Application No: Y/82/20/RES
Site Address: Land to the south of Ford Lane and East of North End Road Yapton BN18 0DS
Description of works: Approval of reserved matters following outline consent Y/80/16/OUT for 4.5ha of residential development comprising of 3.4ha of land for the erection of 100 No. dwellings (up to 30 (30%) affordable housing) together with 1.1ha of land set aside for public open space, strategic landscaping, 2.2ha of public open space, green corridors with vehicular access from Ford Lane & pedestrian/cycle access only from North End Road (resubmission following Y/19/20/RES). This application may affect the setting of listed buildings, affects the character & appearance of the Church Lane, Yapton Conservation Area & affects a Public Right of Way. This site falls within Strategic Site SP2 (Zero Rated).

Thank you for your internet representation made on 24th September 2020 which has been recorded as support with the comments as follows:

Title:
APARTMENT A
FLOOR PLAN AND ELEVATIONS

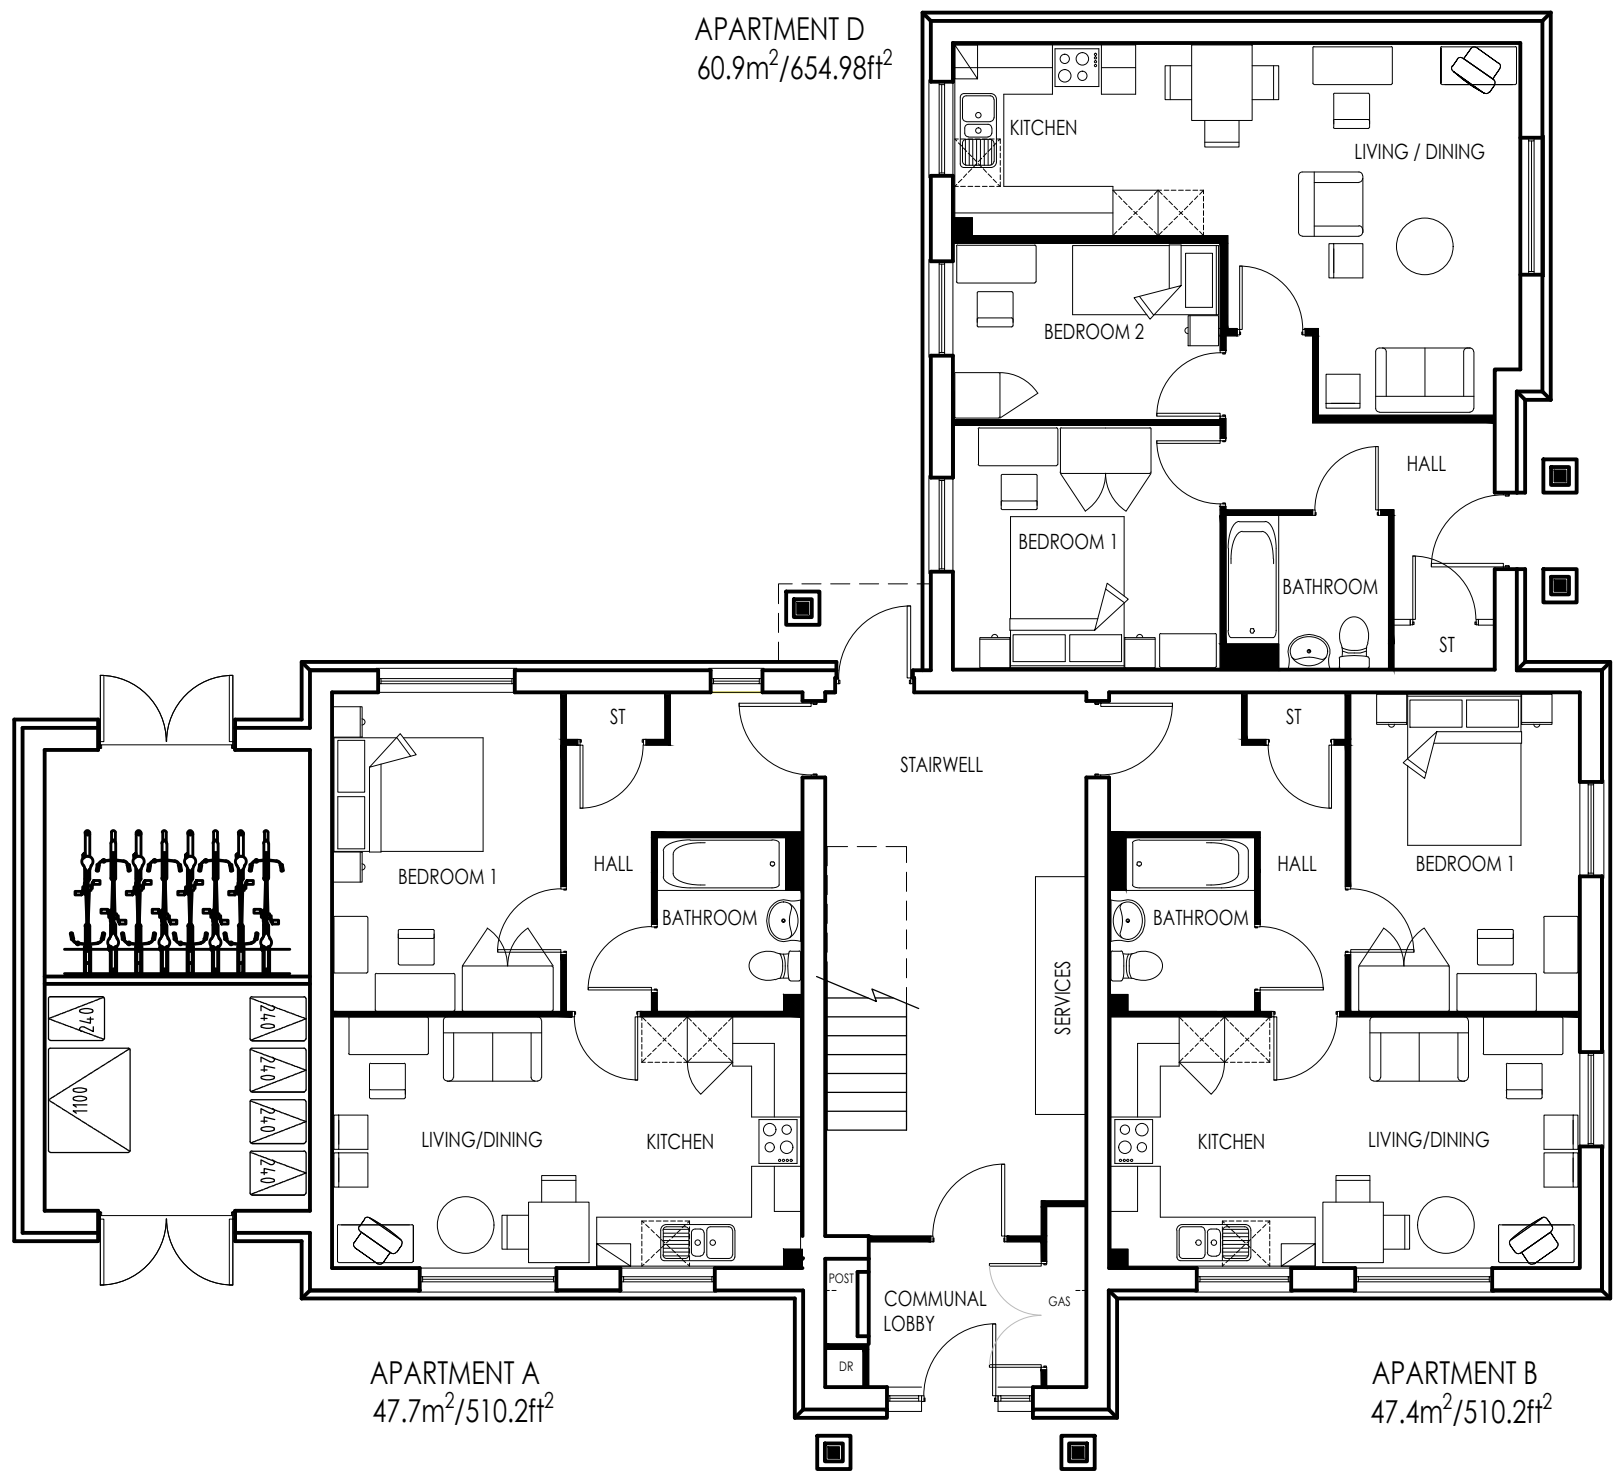
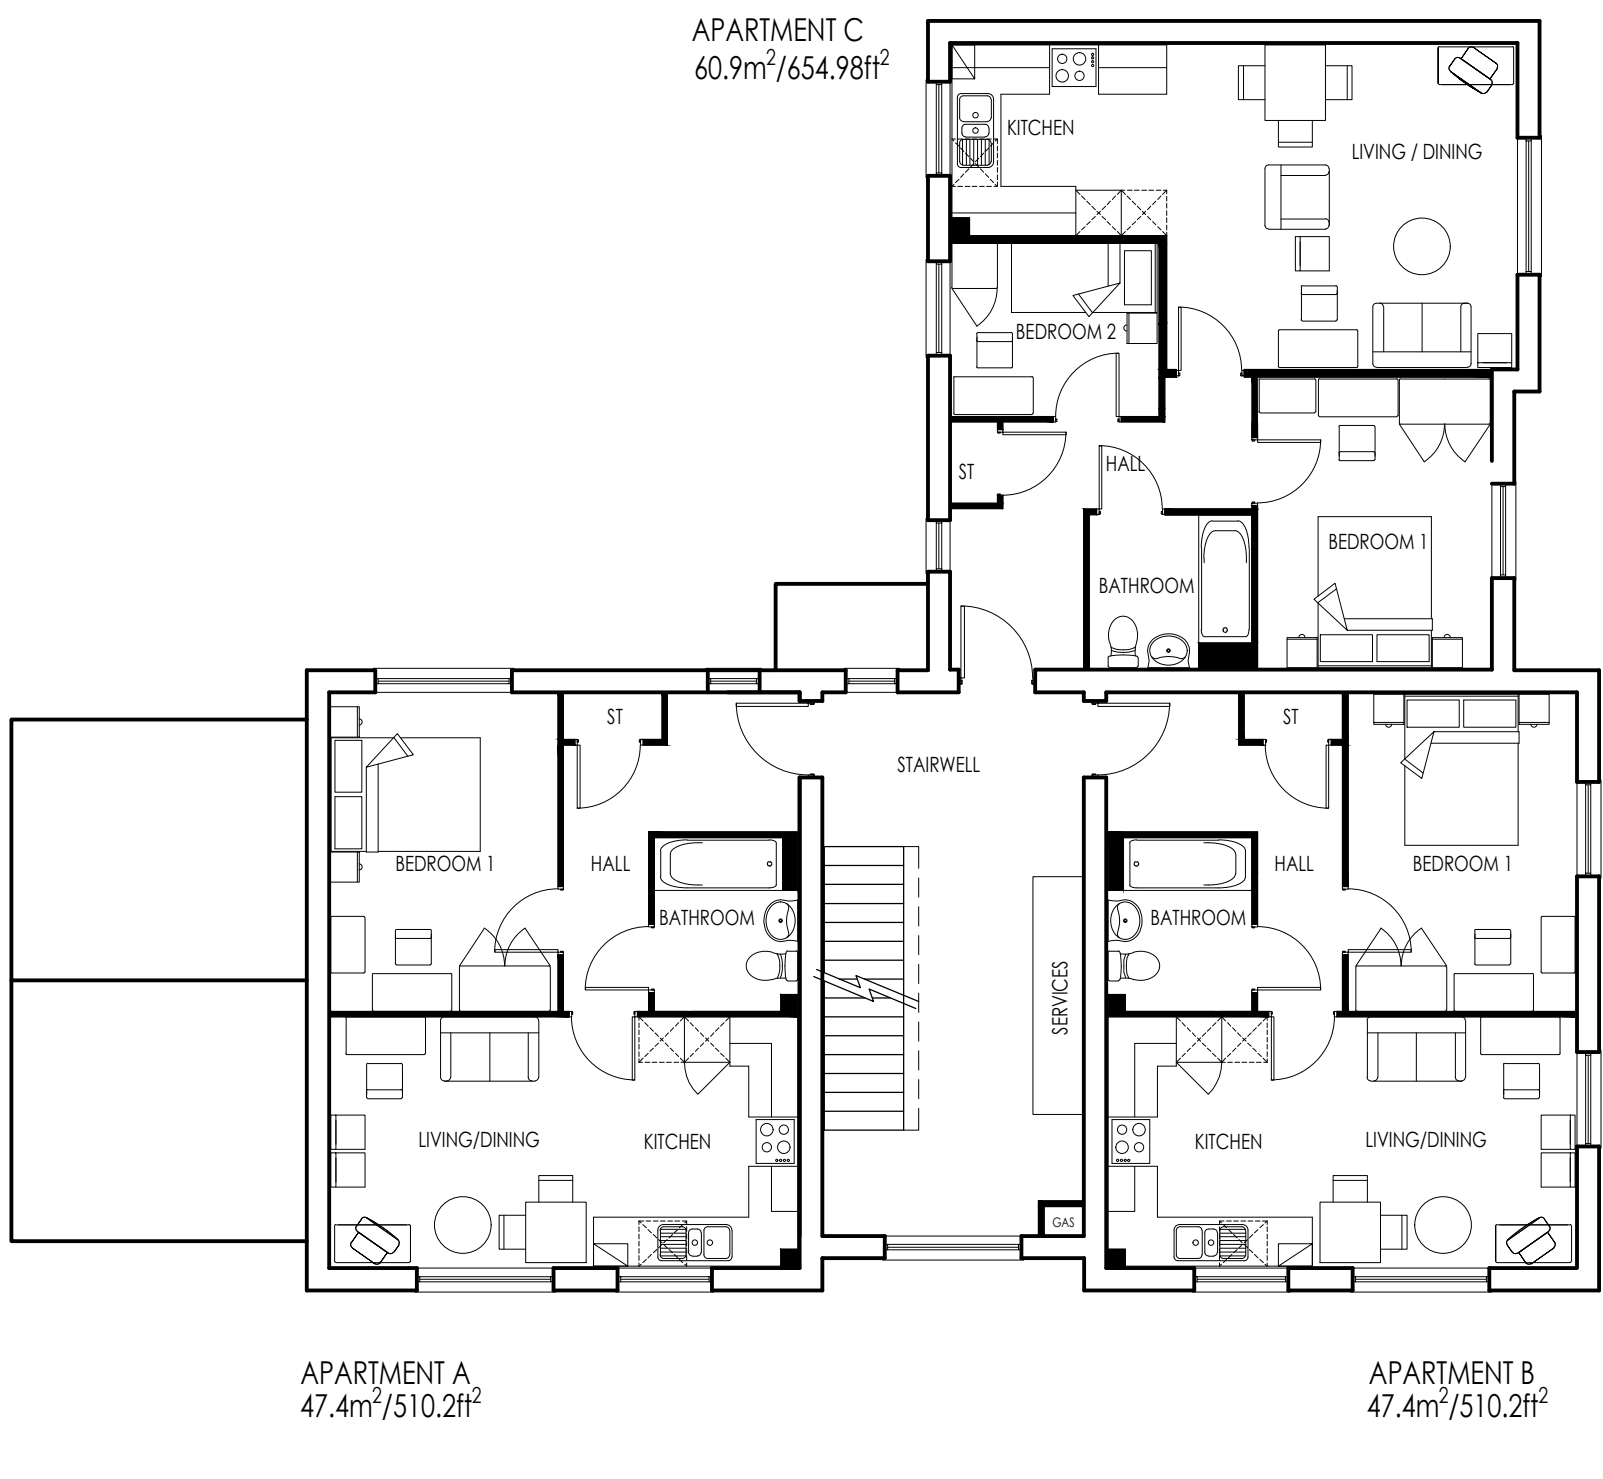
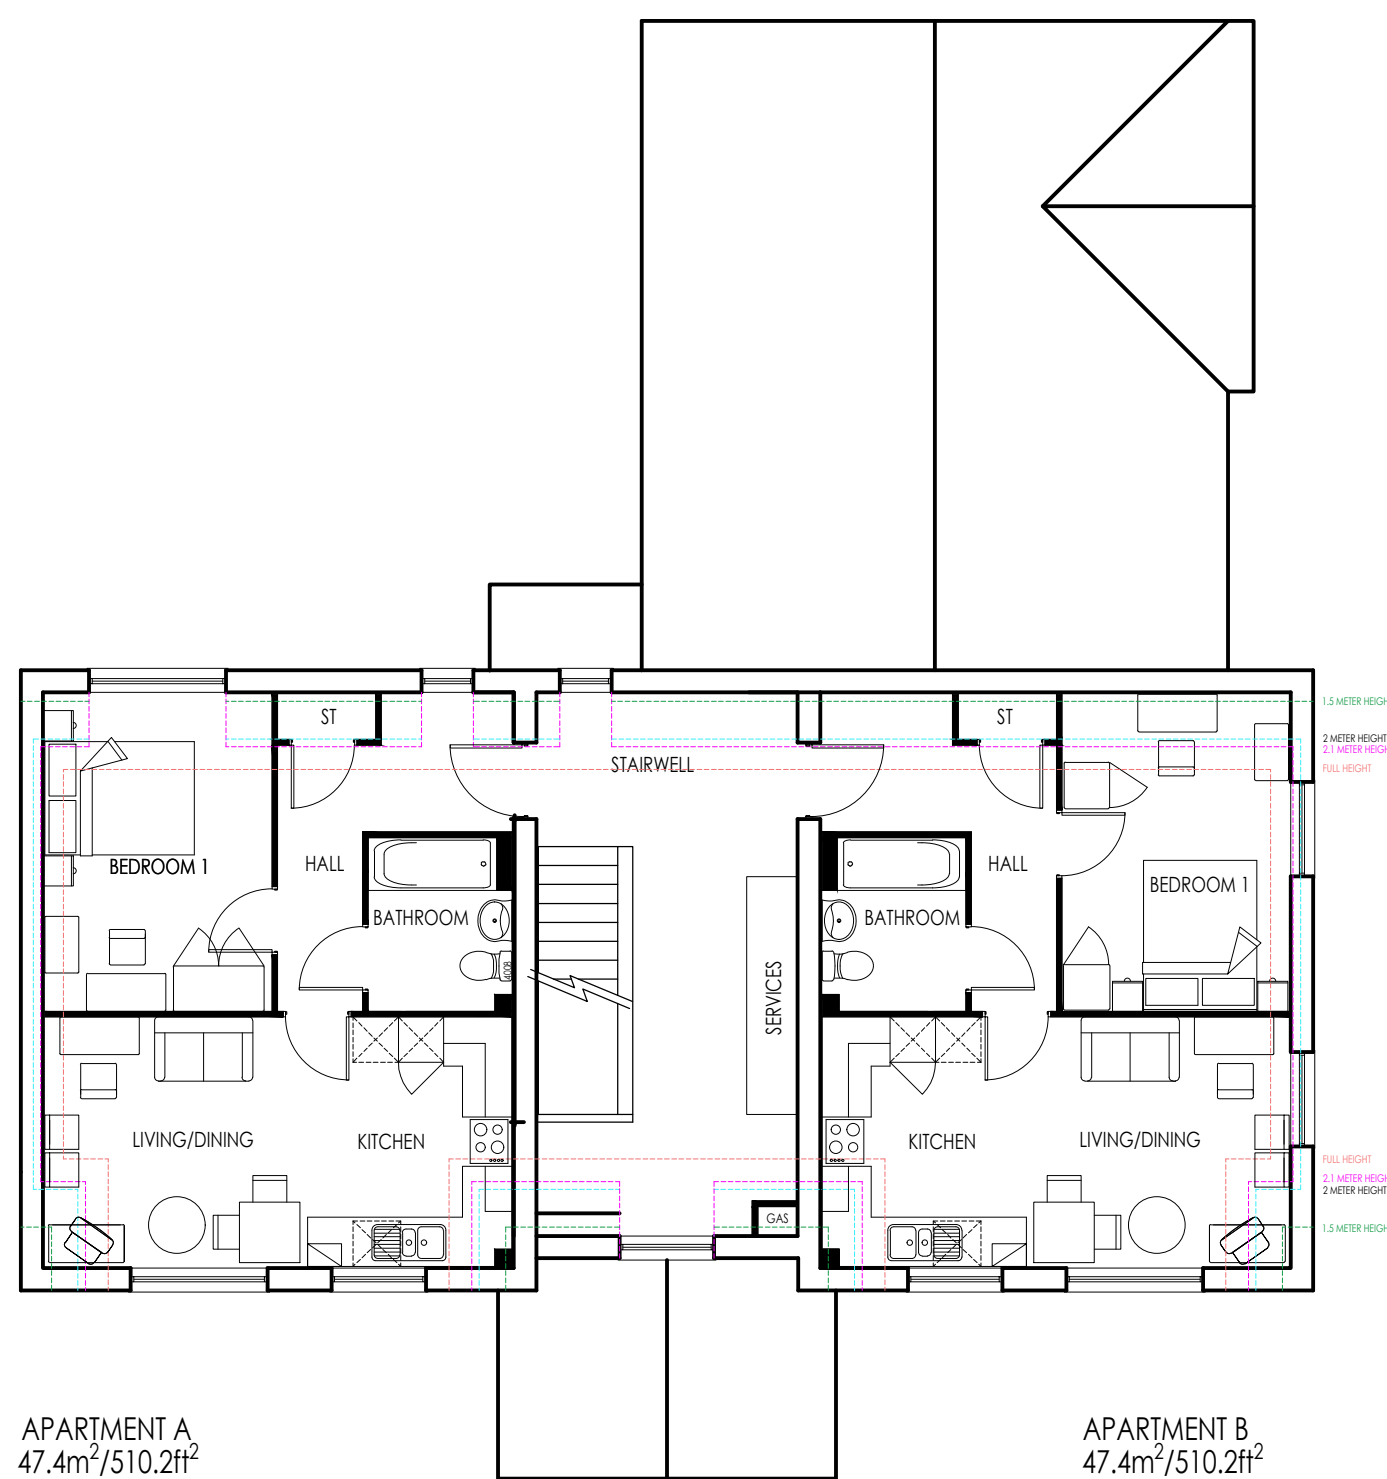
Yapton Parish Council (YPC) recognise that the applicant has continued to engage with YPC regarding the detail of their application. YPC however is unable to change its response from that of 12th March 2020. Comments and request for conditions remain unchanged especially with regard to the height of the two apartment blocks fronting North End Road. YPC strongly believe that the introduction of 3 storey blocks along North End Road's most exposed boundary to be wholly incongruous with the rural street scene in this part of Yapton village. YPC therefore reiterate its request that the roofline be amended to ensure that no building has a greater height than 2.5storeys.

- YPC would welcome suitable smaller housing for the more elderly village demographic which would encourage downsizing within the parish and subsequent churn of existing housing stock.
- YPC Note that plots 64/71 and plots 72/79 fronting North End Road extend to 3 storeys. YPC would request that the units are reduced in height to 2 storey in height or ground levels reduced to create the visual perception of 2 storey buildings. This is to ensure that the streetscape reflects that of North End Road and the
